Application No: LU/100/21/PL
Site Address: Felix Dancewear 39 Beach Road Littlehampton BN17 5JA
Description of works: Change of Use from Office to C3 Residential (This application may affect the setting of a Listed Building)

Thank you for your internet representation made on 4th May 2021 which has been recorded as an objection with the comments as follows:

Existing and Proposed Floor Plans

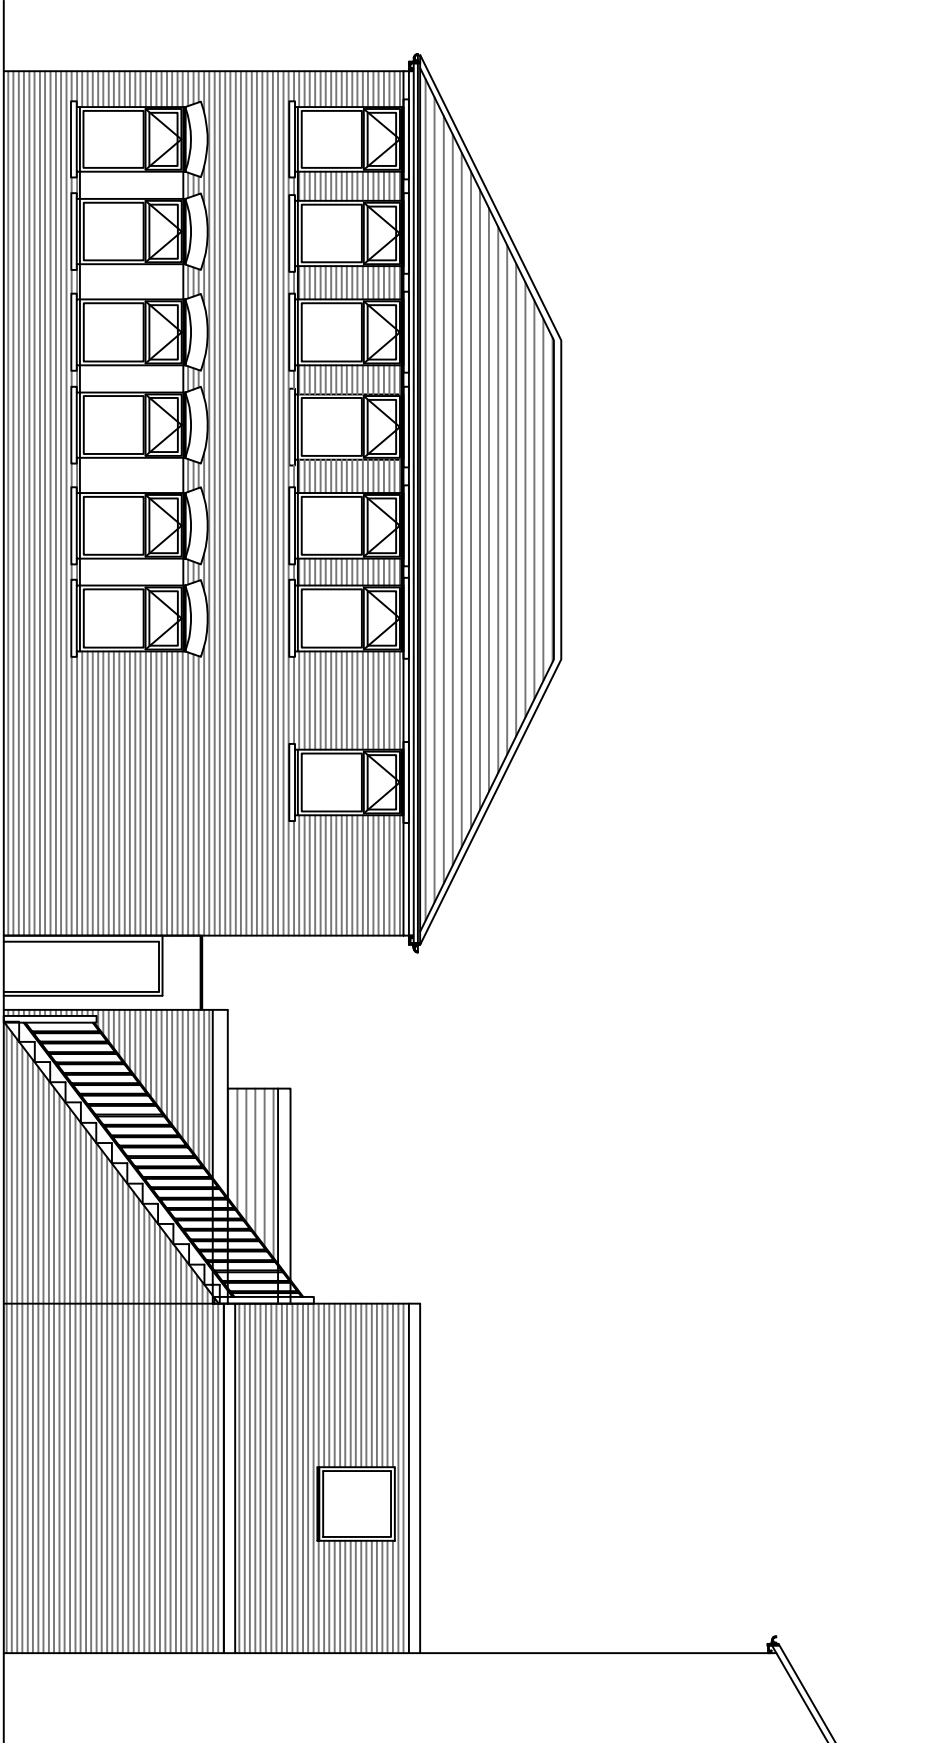
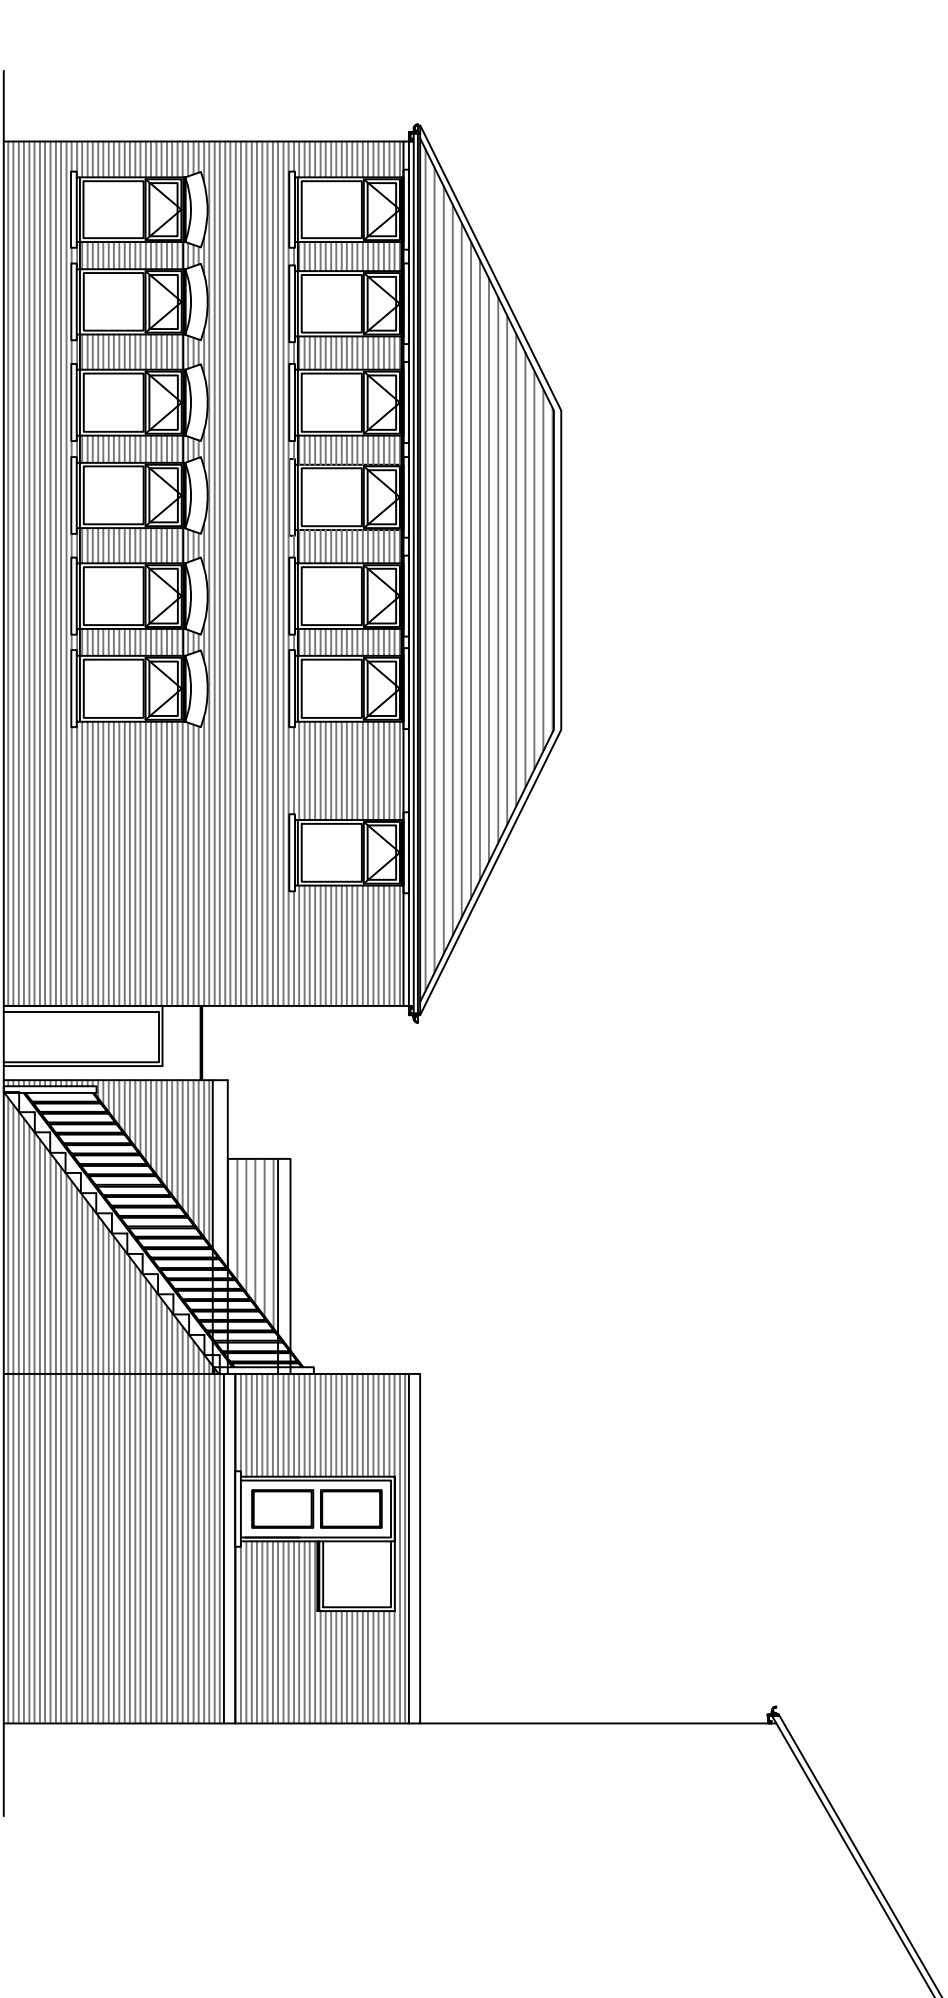
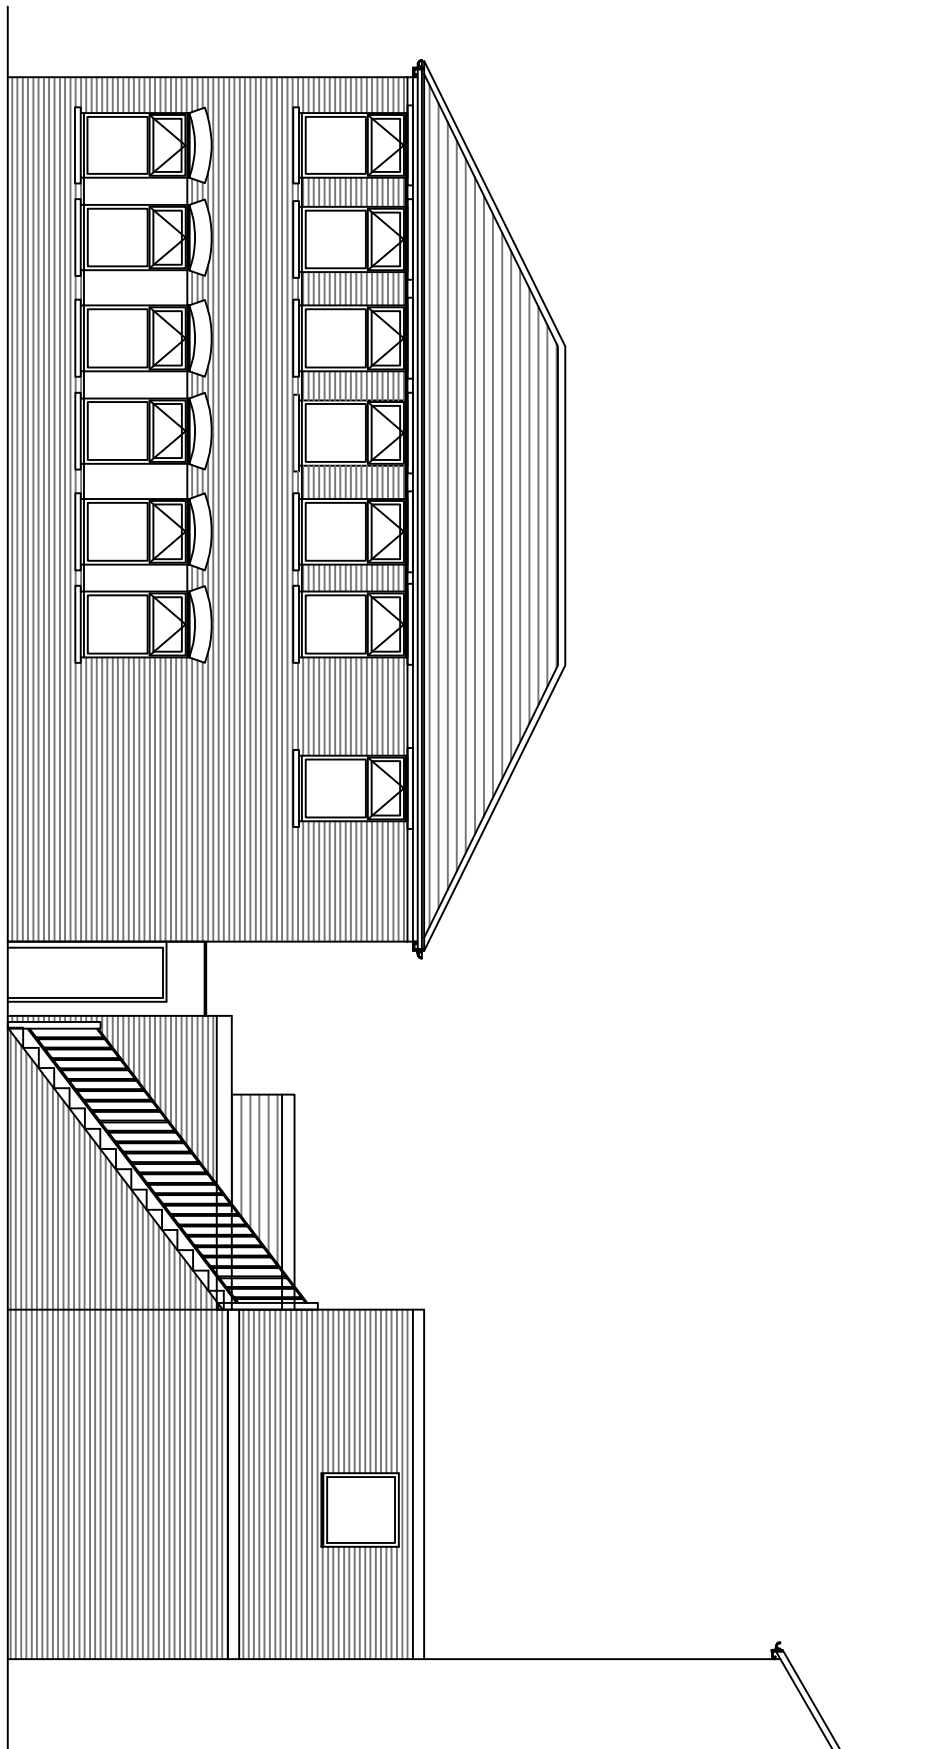
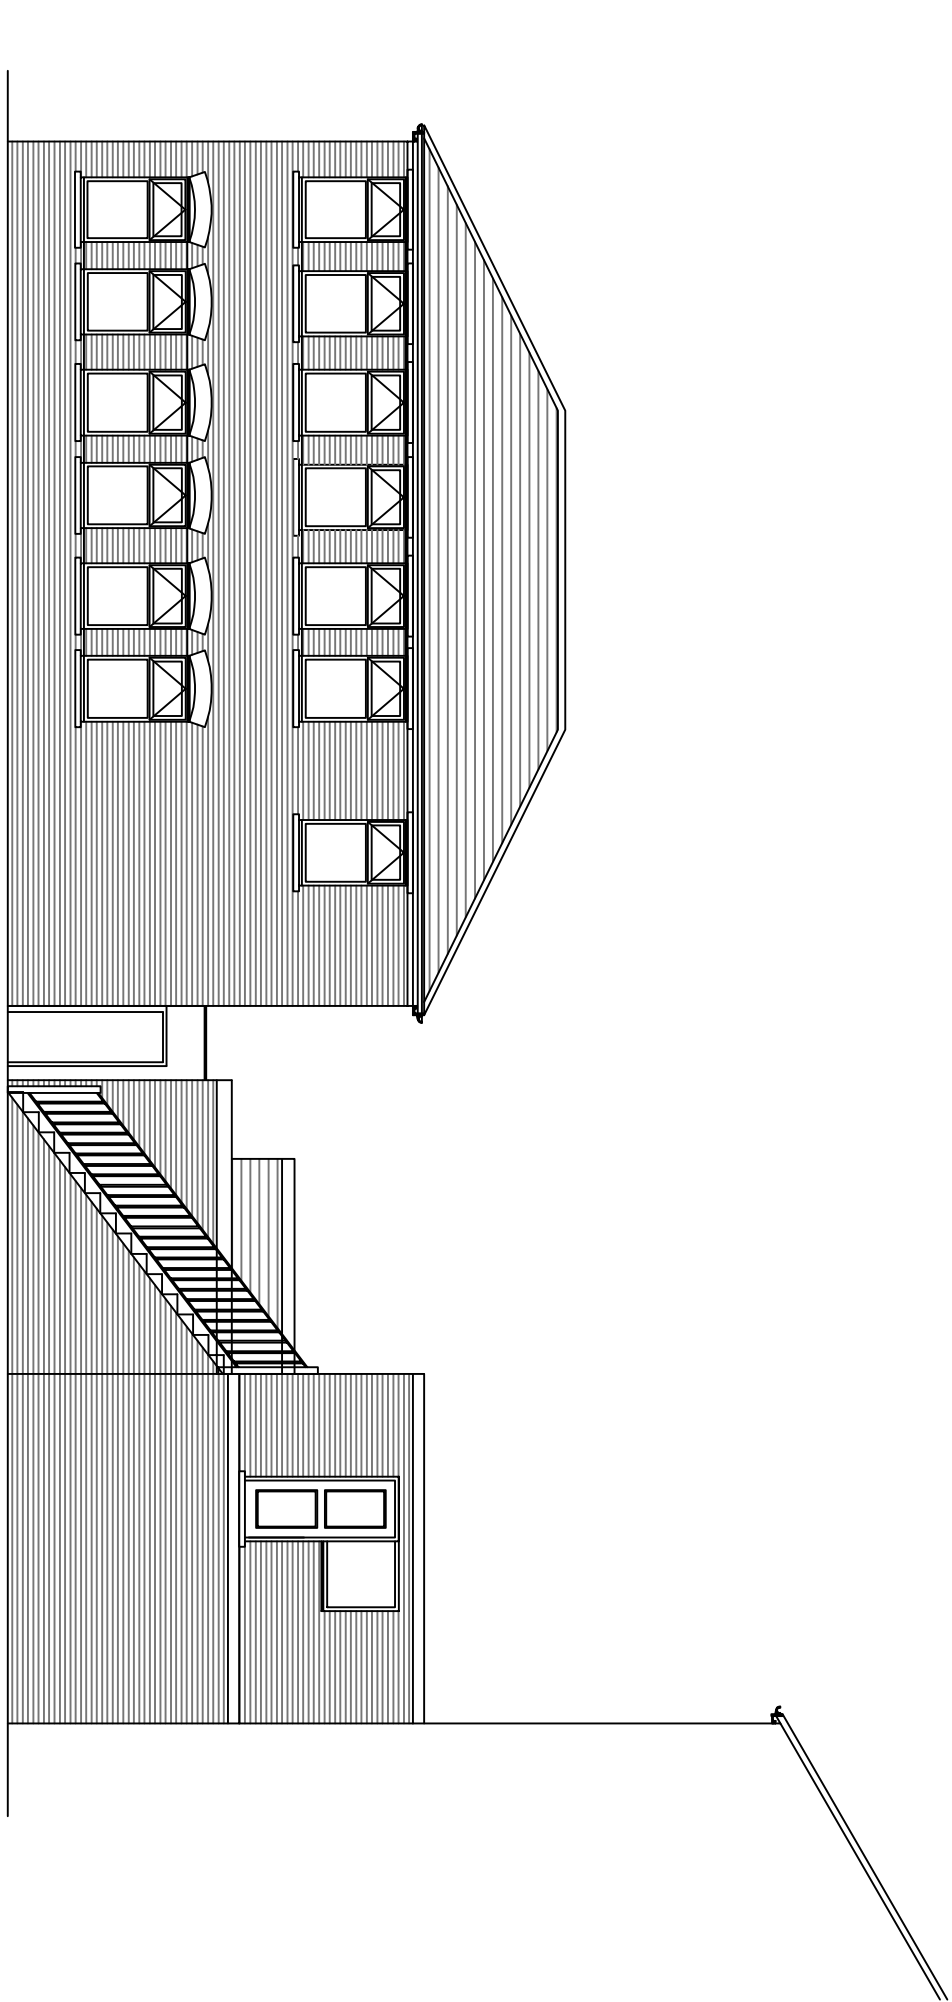
The Town Council's Planning and Transportation Committee considered this matter at its meeting held on Monday 26th April 2021 and objected to the application on the grounds that the proposal does not conform to internal space standards (Local Plan Policy DDM2) with reference to the size of the bedroom proposed.
